From: Laura Gibbons
Sent: 04 June 2018 12:56
To: Planning.Responses
Subject: RE: Planning Consultation on: AL/38/18/PL

Engineers comments in respect to surface water drainage:

APPLICATION AL/38/18/PL

Description of Works: Construction of additional car parking, with lighting, to serve existing Gospel Hall.

Figure 3: Proposed Drainage

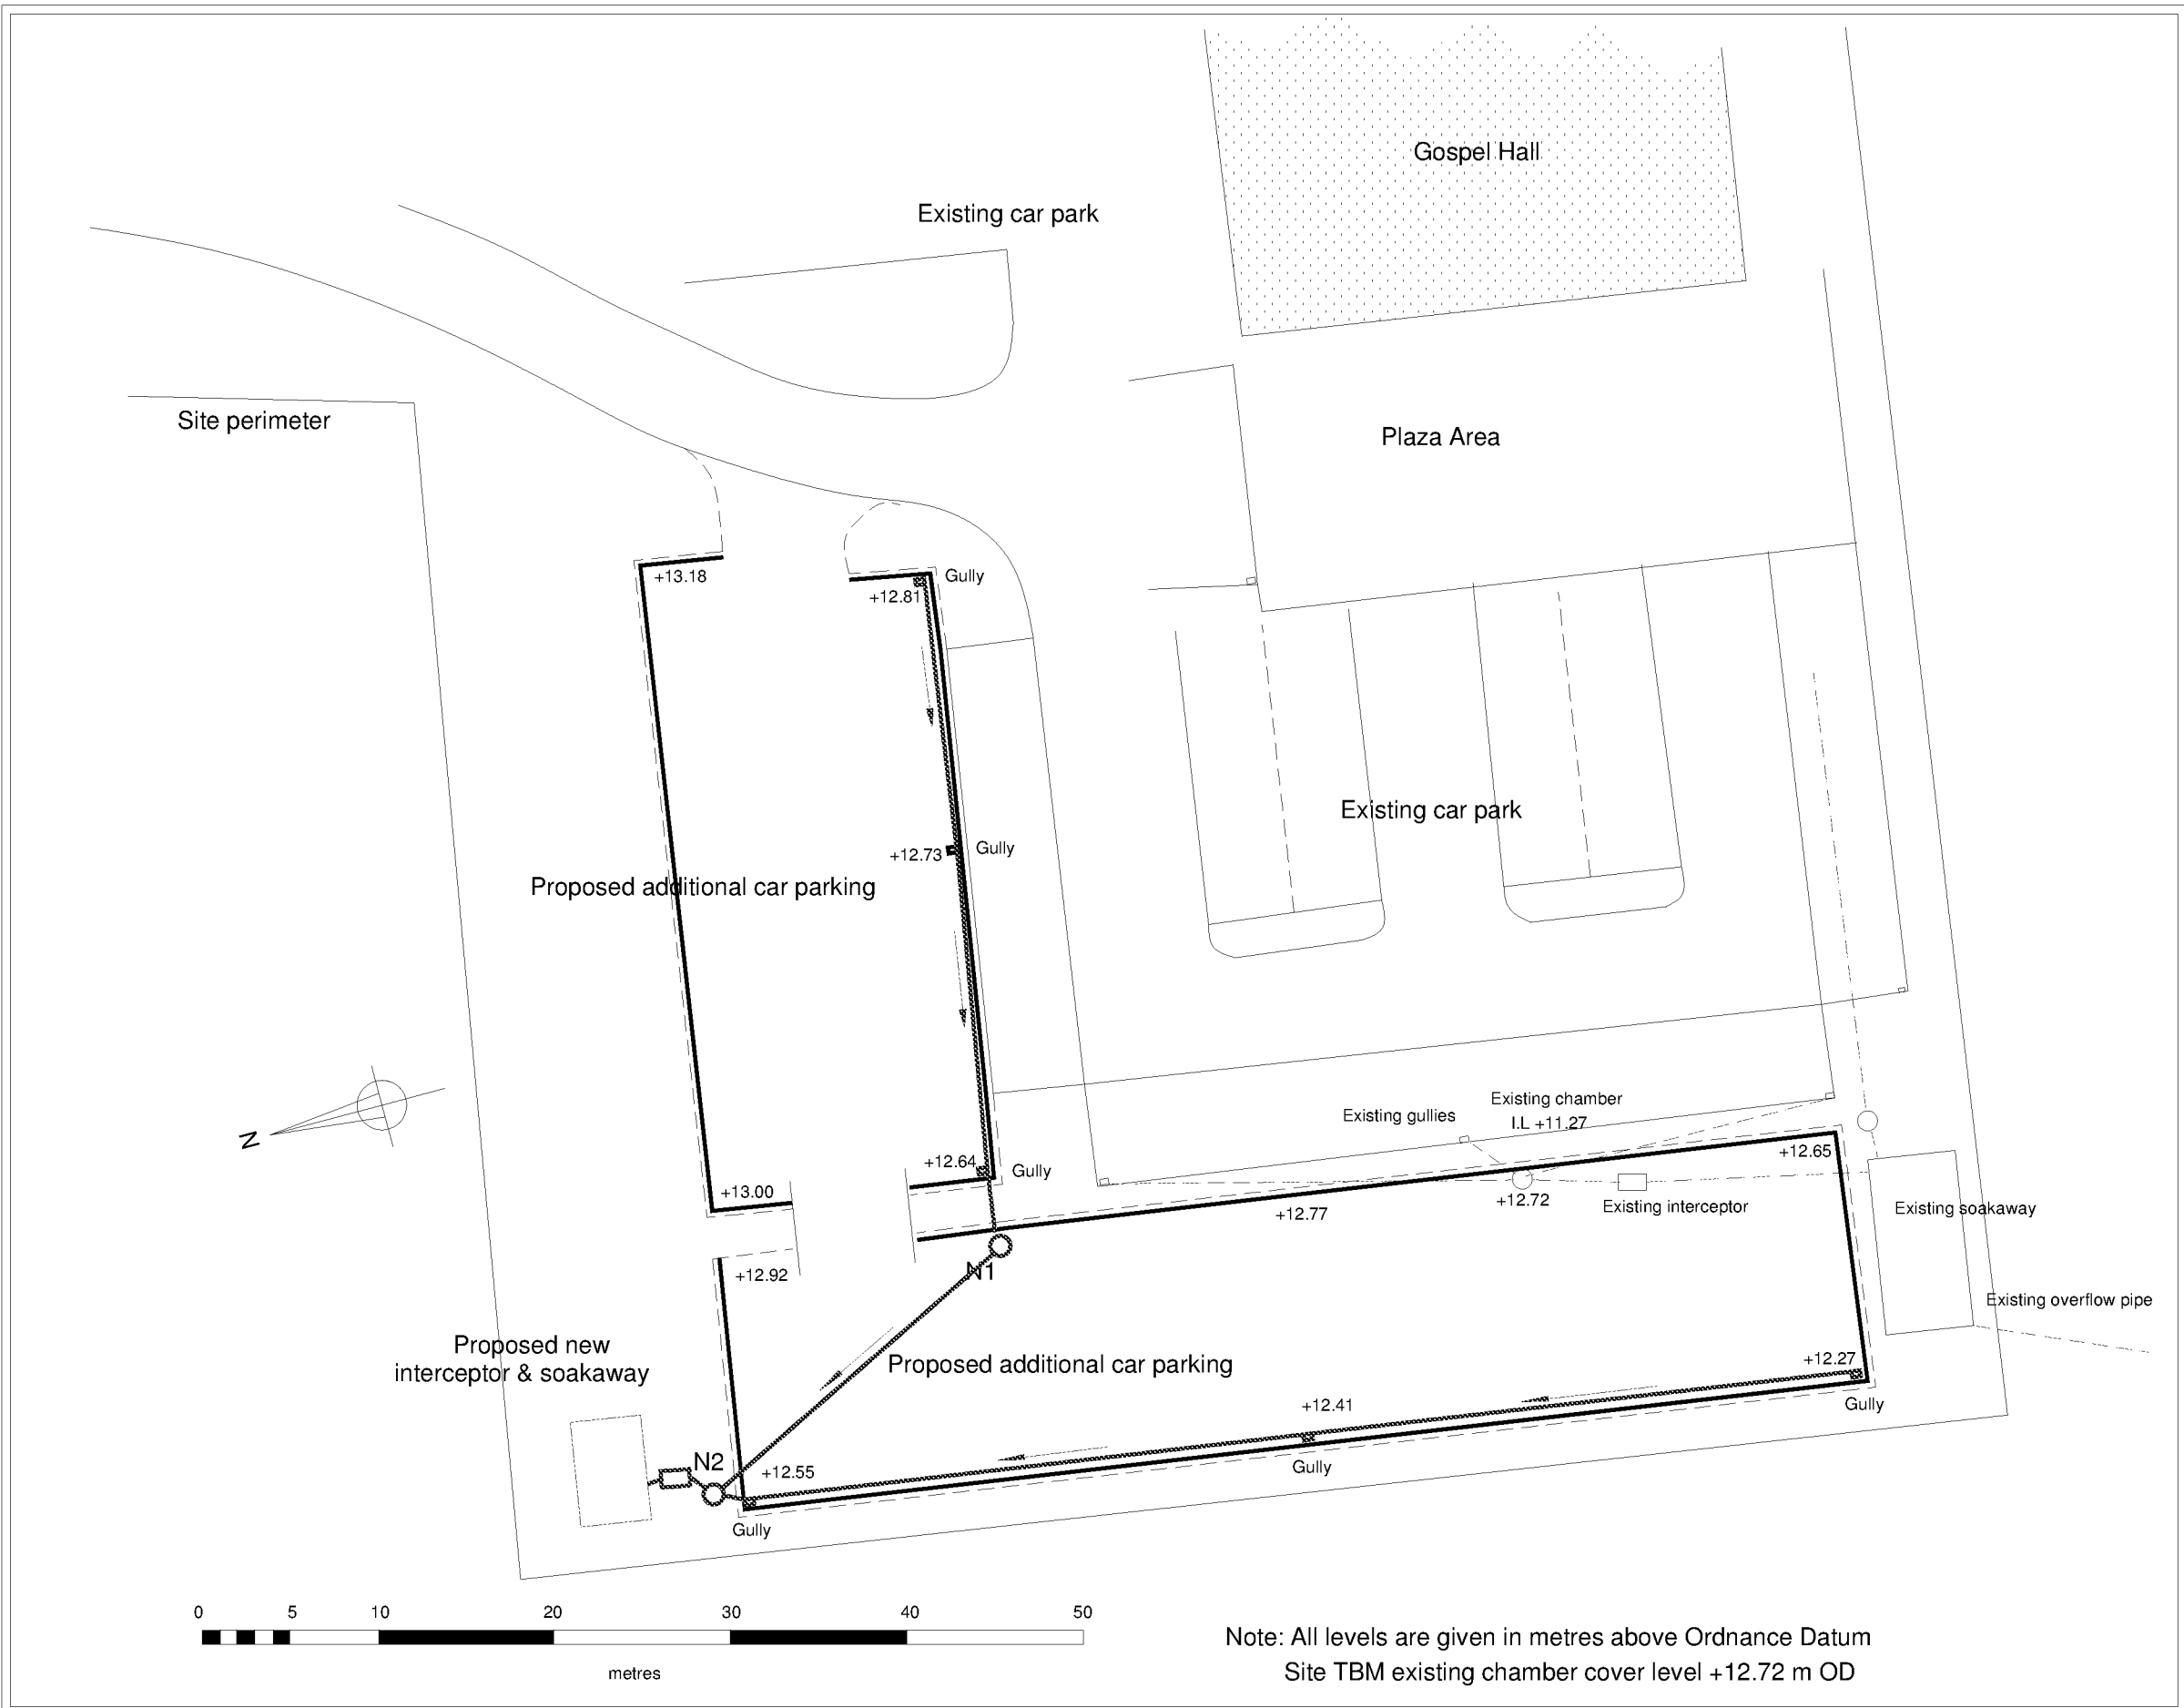
Soakaways must be investigated for surface water disposal.

Infiltration rates for soakage structures are to be based on percolation tests undertaken in the winter period and at the location and depth of the proposed structures. The percolation tests must be carried out in accordance with BRE 365, CIRIA R156 or a similar approved method and cater for the 1 in 10 year storm between the invert of the entry pipe to the soakaway, and the base of the structure. It must also have provision to ensure that there is capacity in the system to contain below ground level the 1 in 100 year event plus 40% on stored volumes, as an allowance for climate change. Adequate freeboard must be provided between the base of the soakaway structure and the highest recorded annual groundwater level identified in that location.

Any SuDS or soakaway design must include adequate groundwater monitoring data to determine the highest winter groundwater table in support of the design. The applicant is advised to discuss the extent of groundwater monitoring with the Council's Engineers. Supplementary guidance notes are also enclosed for information.

I note that percolation test results and drainage designs have been included with the planning submission. However, no winter groundwater monitoring has been recorded and the test pits have been dug far too deep. We would expect winter groundwater levels to be far higher than 3m. Therefore shallower infiltration structures will need to be used. Percolation tests should be conducted at the base of the proposed structure. The use of permeable paving could also be investigated for this site.
